Recommendation Report for Planning Permission for Works or Extension to a Dwelling

REF NO: P/91/26/HH

LOCATION: 11 Manor Park
Pagham
PO21 3JS

PROPOSAL: First floor extension.

WEST

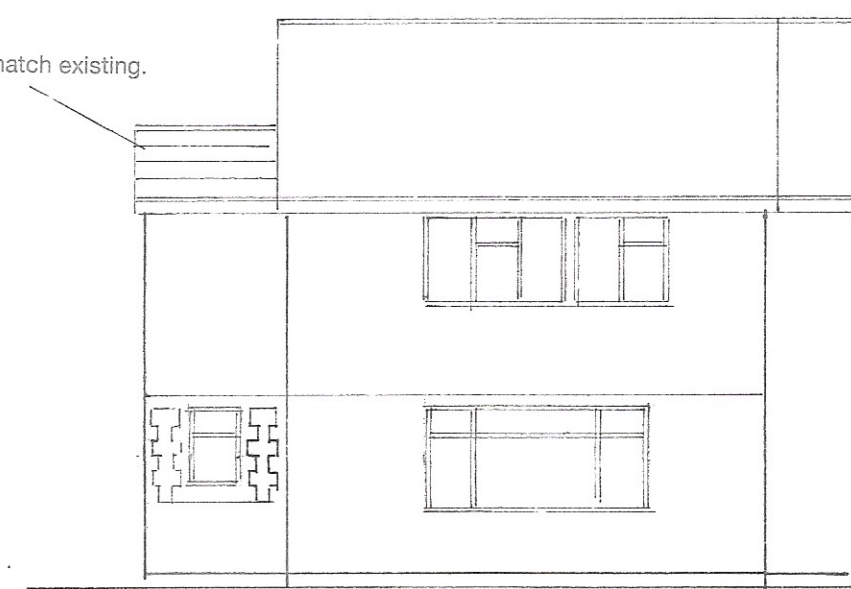
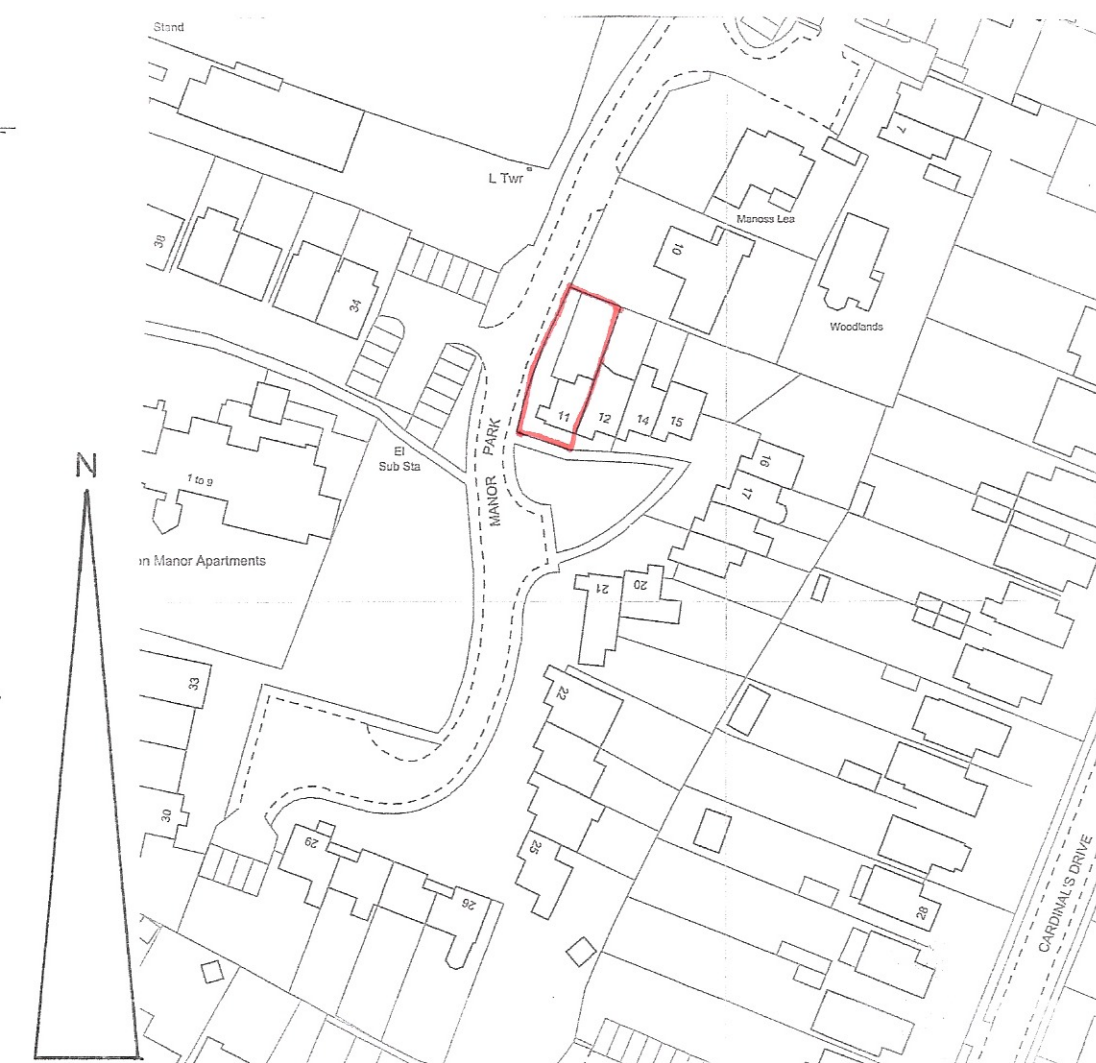
The proposed first-floor side extension would extend over the existing single-storey porch and would measure 1.8m wide and 1.6m deep. It would have a pitched roof, with an eaves height of 4.9m and a maximum height of 6.1m, set 1.4m below the ridge of the main roof. While the extension does not fully accord with Part M of the Arun Design Guide (ADG), which encourages first-floor extensions to be set back from the front elevation, the extension would be stepped down from the main ridge line of the host dwelling and would be modest in its proportions, ensuring that it would remain visually subservient. As a result, the extension would not appear unduly prominent when viewed from the street and would not detract from the character or appearance of the host dwelling or the surrounding street scene. The proposal is therefore acceptable in design terms, despite the minor departure from guidance.

The extension would be finished in white cement board cladding. While this material is not present on the host dwelling, there are examples of cladding elsewhere along Manor Park, including at Nos. 10, 9, 8 and 7 to the rear. As such, its introduction would not appear incongruous within the character and appearance of the locality.

Fenestration is proposed within the western elevation of the proposed first-floor side extension. This would provide views over the highway and towards a garage compound and would not be significantly different from the views available from the existing window within this elevation. The proposed fenestration would not result in additional overlooking.

1ST FLOOR PLAN

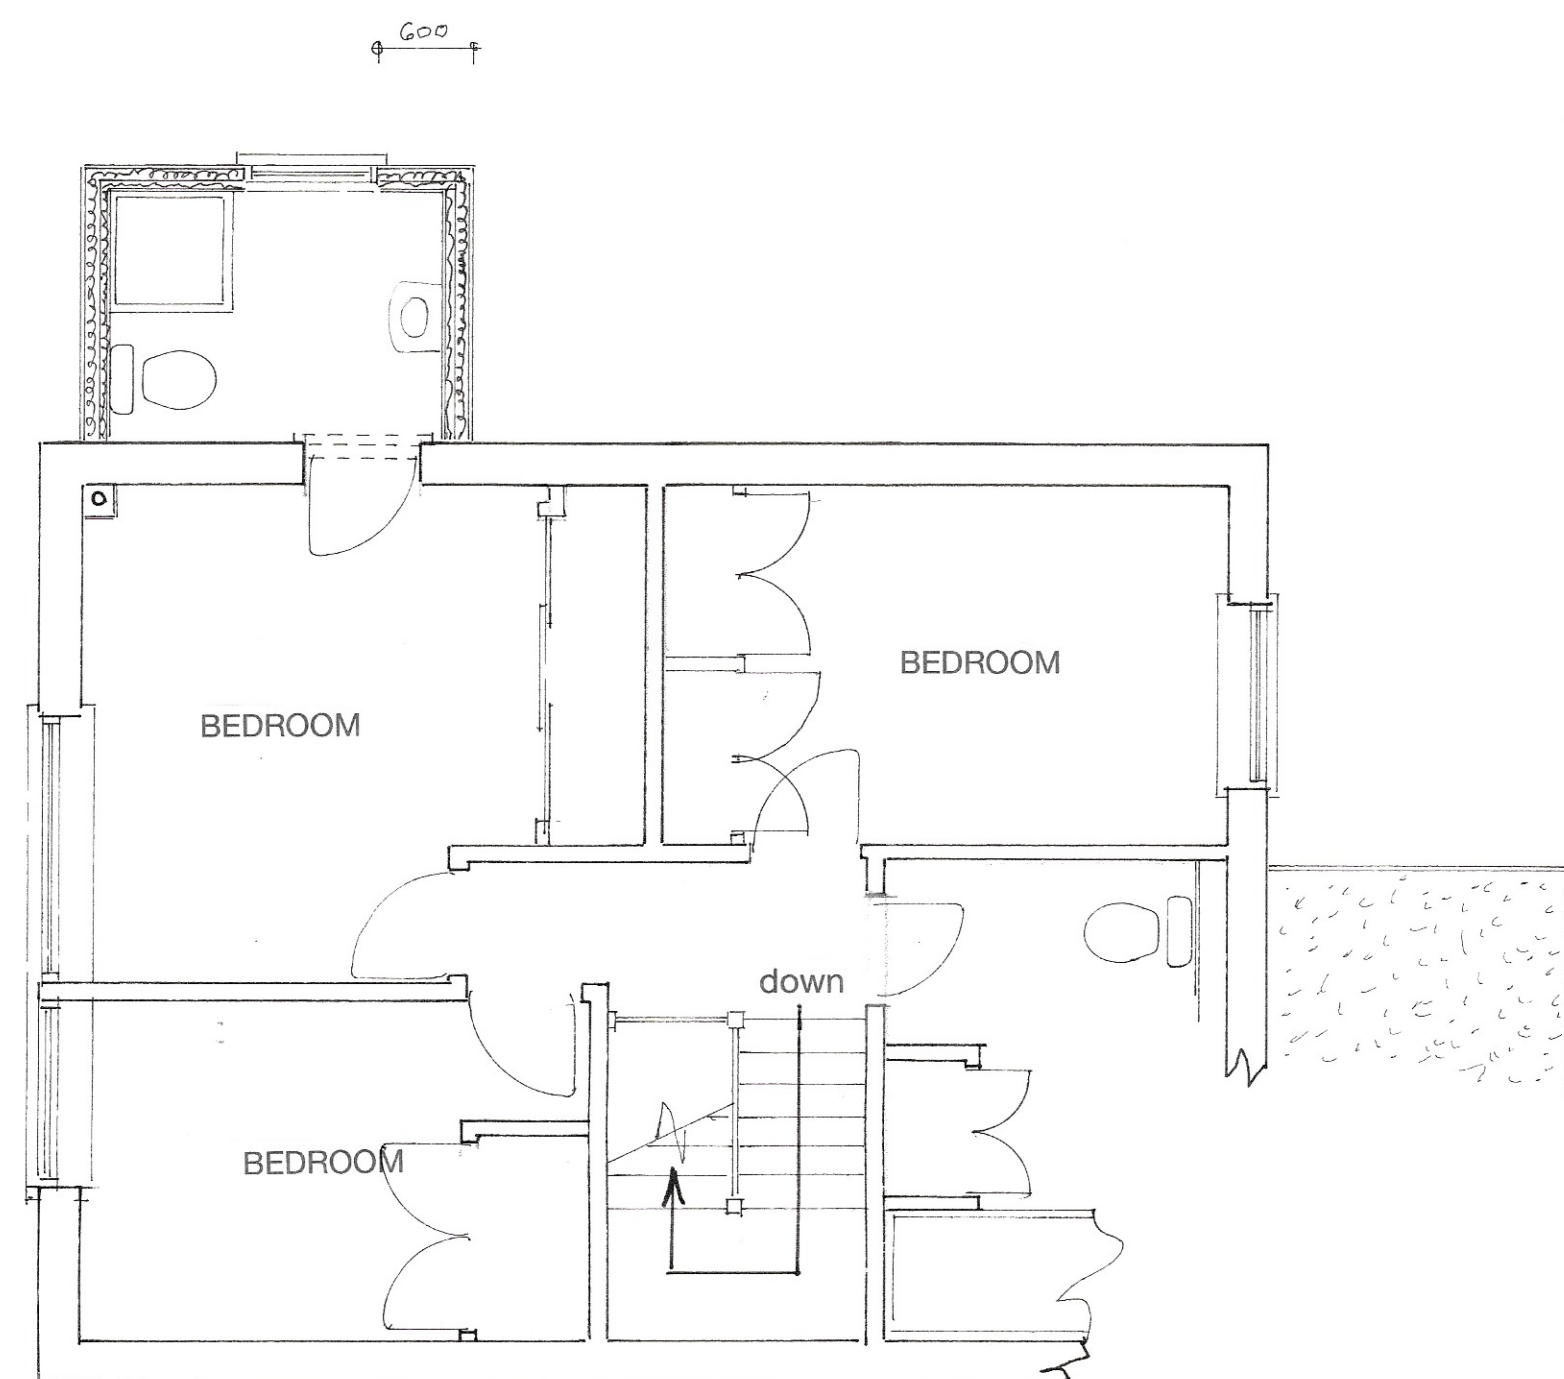
The proposed first-floor extension would remain within the existing footprint of the dwelling. Given the siting of the plot and the extension within it, it would not project further towards neighbouring properties. Furthermore, the extension would be set in from the side boundary with Manor Park by 2.8m and from the front boundary with the footpath serving the terrace by 3.5m. It would therefore not result in harm to neighbouring occupiers. Accordingly, no overbearing or overshadowing impacts would arise as a result of the first-floor side extension.
